From: Sue Howell <Sue.Howell@arun.gov.uk>
Sent: 27 May 2021 17:23
To: Planning.Responses <Planning.Responses@arun.gov.uk>
Cc: Anita Gardner <Anita.Gardner@arun.gov.uk>
Subject: Planning Consultation on: LU/116/21/PL

Response to Planning Application

Application ref: LU/116/21/PL

Location: Land South Of The Littlehampton Academy Fitzalan Road Littlehampton BN17 6ED

ILLUSTRATIVE SITE PLAN -  
80 HOUSES AND 32 APARTMENTS

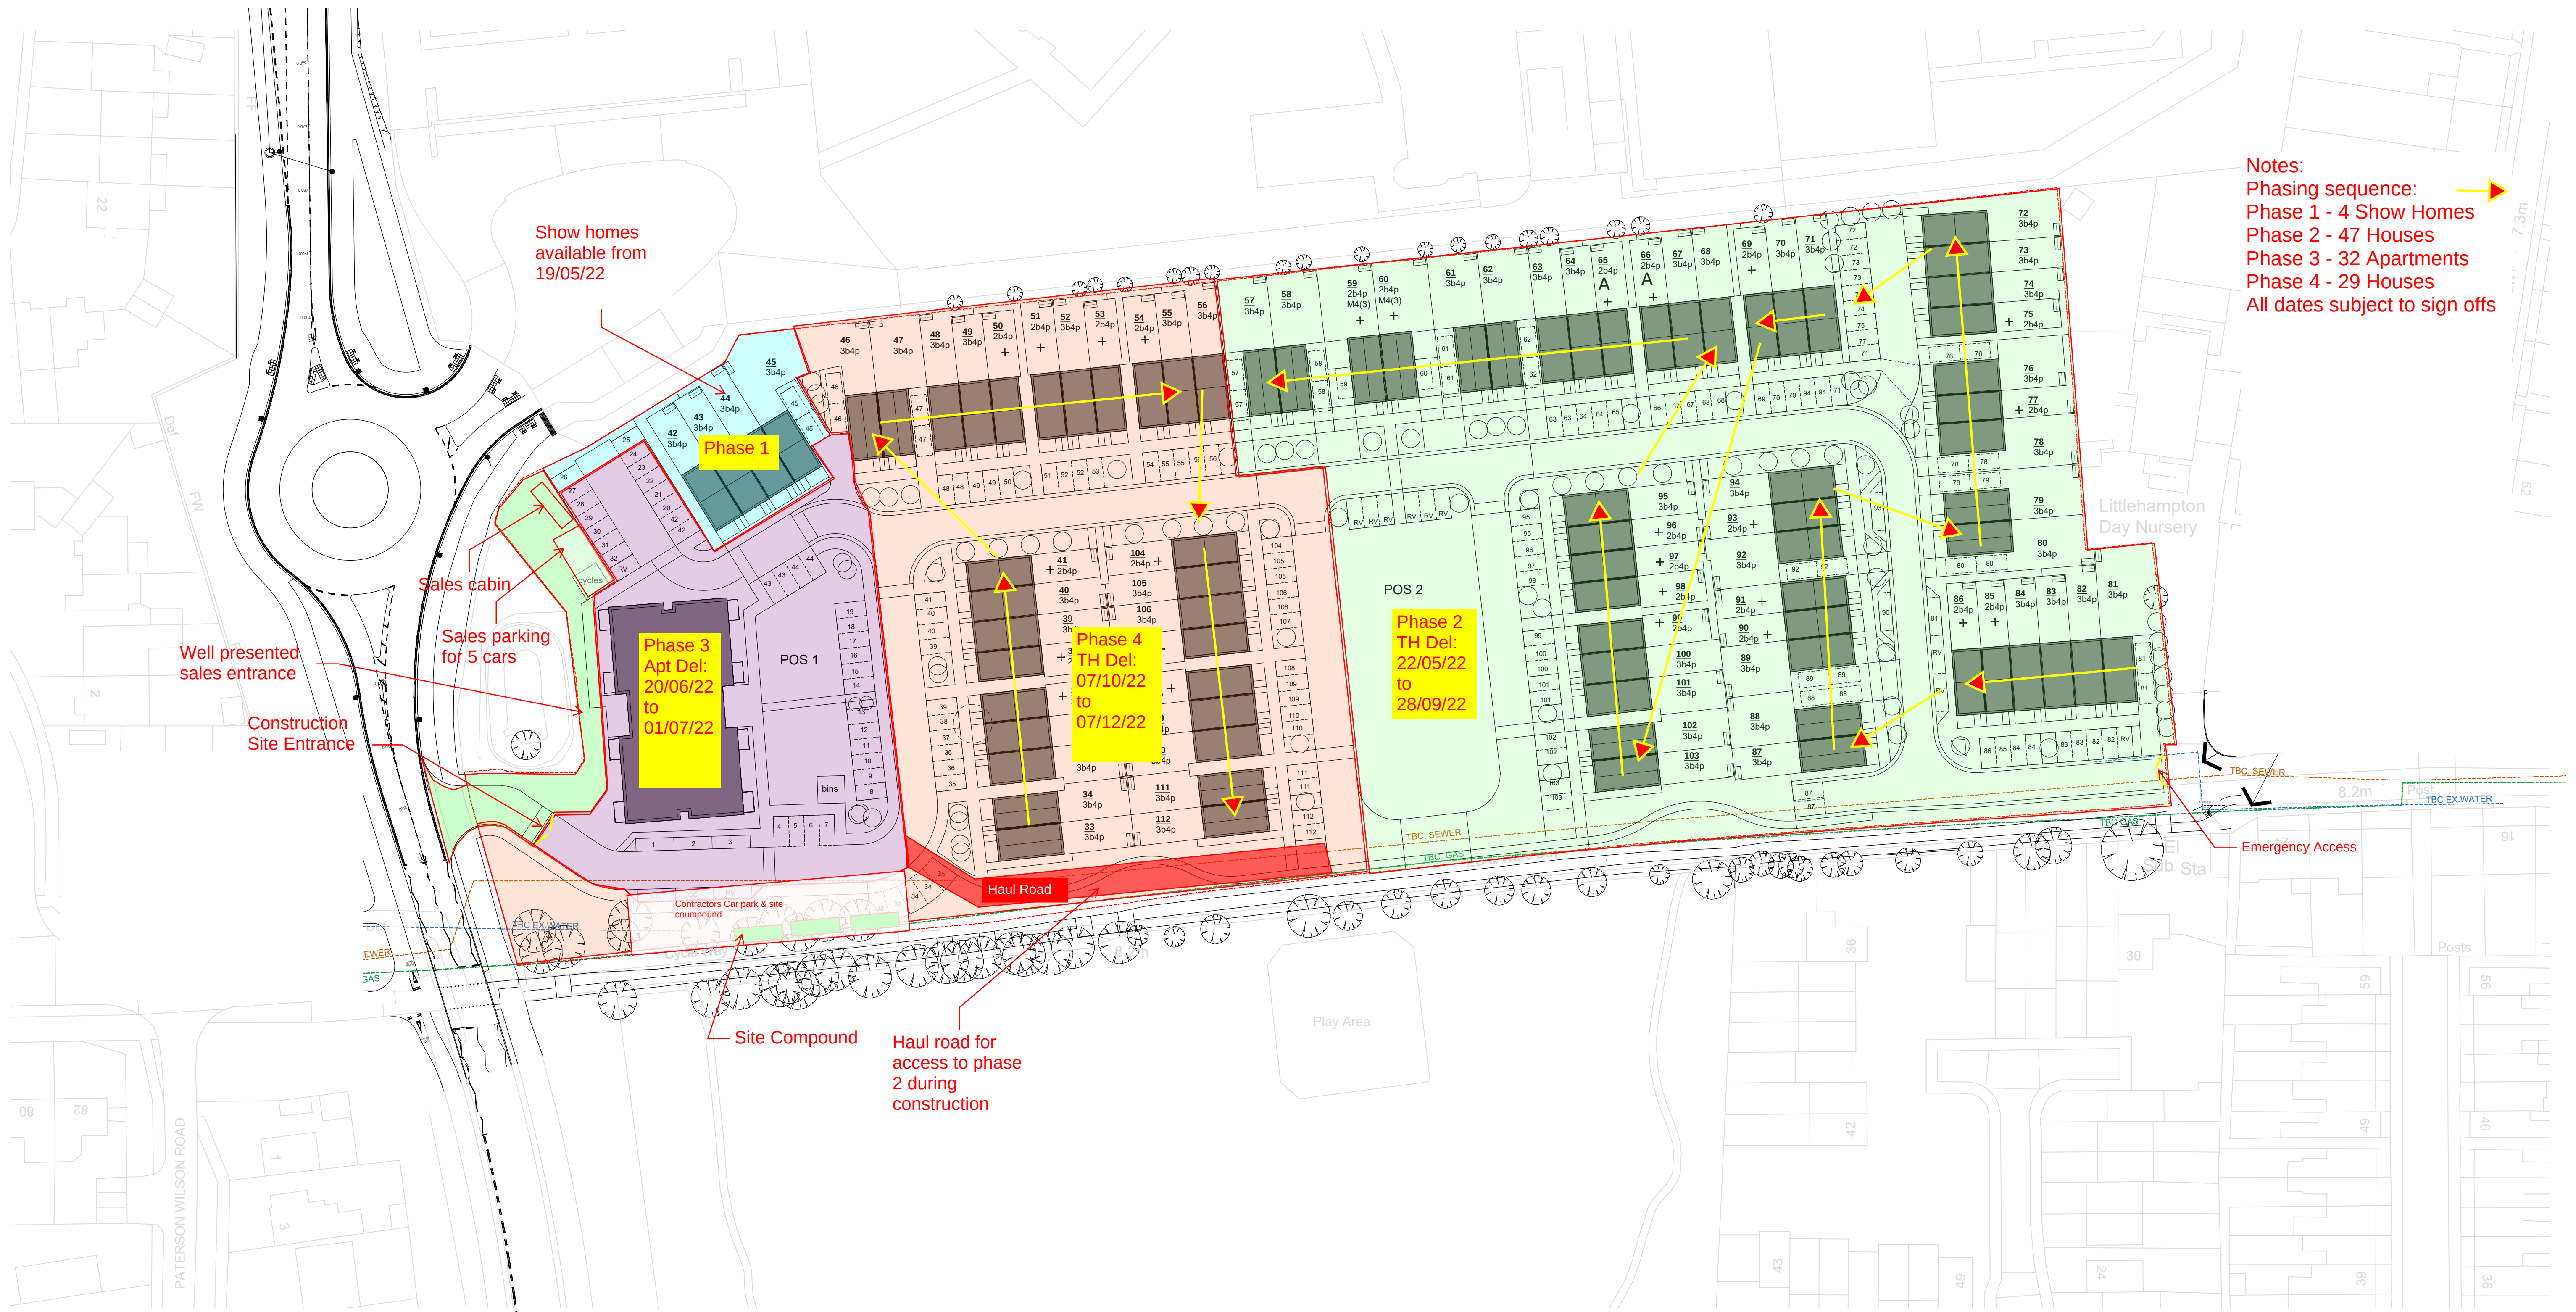
The detail under LU/55/15/OUT (68 dwellings) included a Public open space area centrally located within the development. The proposals under this application LU/116/21/PL show a central POS area which appears to now contain children's play, plus an area of private open space to the apartment block which now houses SuDS provision. The density of dwellings now proposed 112no units will need to demonstrate that the POS minimum standards are being met with these dwelling numbers, excluding and SuDS areas which should not form part of the POS calculations. It should be noted that 9240sqm of onsite POS is required in addition to offsite financial contributions for playing pitches/3G pools/ halls and ancillary facilities as outlined in ADC SPD Open Space, Playing Pitches, Indoor and Built Sports Facilities January 2020.

It has previously been recommended for play that a preference for offsite provision with a financial contribution for offsite provision made. It would be advised that play would be better situated as an offsite contribution and as agreed in the previous 106 application rather than located on this site. In addition, the total quantum required for POS and play on site for 112 dwellings would be 9240sqm (including 1356sqm of play space) which from the layout shown would appear to not be achievable. On these grounds alone recommendation would be that the POS being provided for this development is insufficient to accommodate play as well as general Public Open Space.

LAP provision in the form of natural unequipped play spaces, would also be required within the proposals, but not presently shown.

The POS being shown with this application would appear insufficient for a development of this many dwellings, clarification to be sought re quantum being provided.

SuDS provision appears to have been incorporated to the apartment block area, the full implication of these including future management and maintenance must be considered, also the proximity to these residential dwellings. The recommendation that these are subject to RoSPA or similar organisation inspection should be noted. Detail to be provided as to whether these are likely to be wet or dry areas; this has implications where situated near to residents and play areas. Where they are to remain wet for long periods their safety must be assessed regarding the proximity to residential areas. Any such SUDS features should be designed as beneficial wildlife, amenity and landscape features and incorporated as part of an open space or landscaping scheme for the development.
